From: Amanda Scholes on behalf of Planning.Responses
Sent: 25 April 2019 11:32
To: Planning Scanning
Subject: FW: F/30/18/PL - Drainage comments

Thank you for your comments concerning our application to erect multispan polythene tunnels at Wicks Farm, Ford – F/30/18/PL.

Subject: F/30/18/PL - Drainage comments

Drawing Title
Proposed Drainage Layout

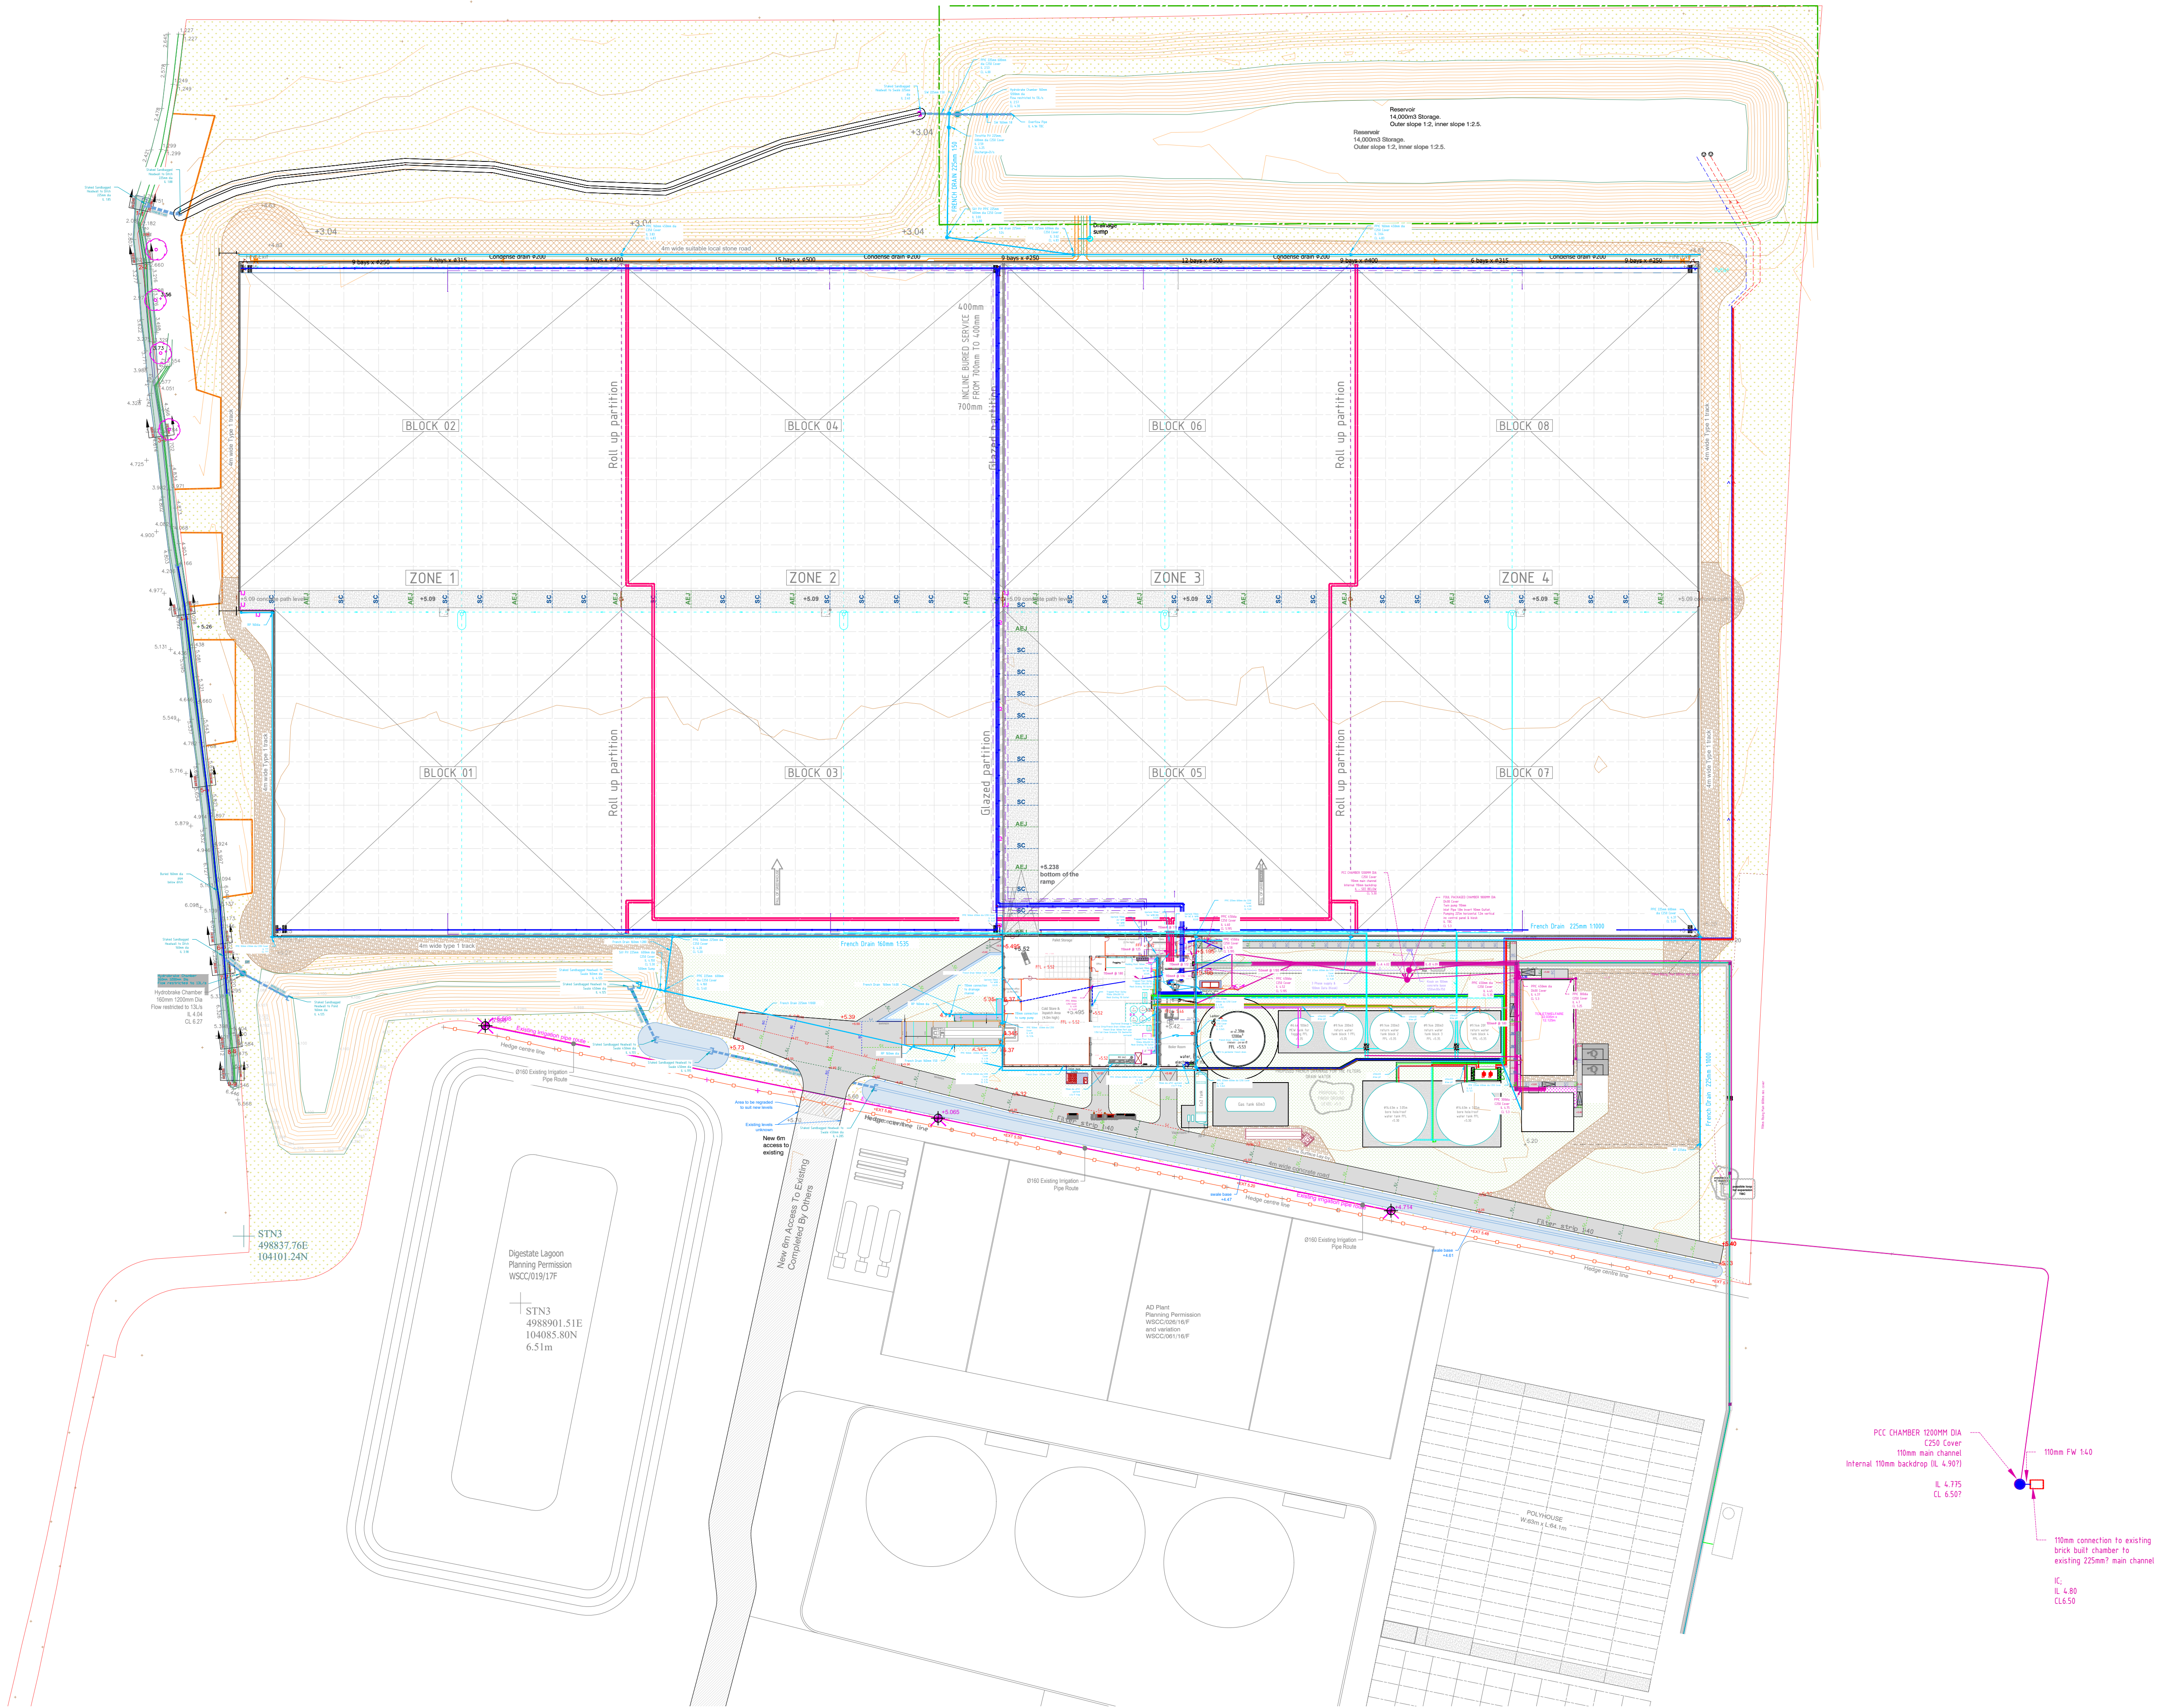
And no the information is inadequate, at the minute I have no confidence that the proposals will not increase flood risk elsewhere, including the PRow. Clarification of where the surface water is discharging would be a good start. Proposed levels across the site would also be of benefit.

Also does the drainage information provided provide evidence that the Public Right Of Way to the west of the site and along the proposed access road will be adequately protected in terms of surface water drainage?
Is any more information required to demonstrate this?

The Access & Design Statement explains and the technical drawing shows that all the rain water falling on the multispan polythene tunnels will drain North to the new reservoir planned for the lowest part of the field. An overflow system will be designed to take surplus water to the existing local ditch system and onward directly to the River Arun.

There are no plans to drain any rain water towards the Public Right Of Way (PROW).
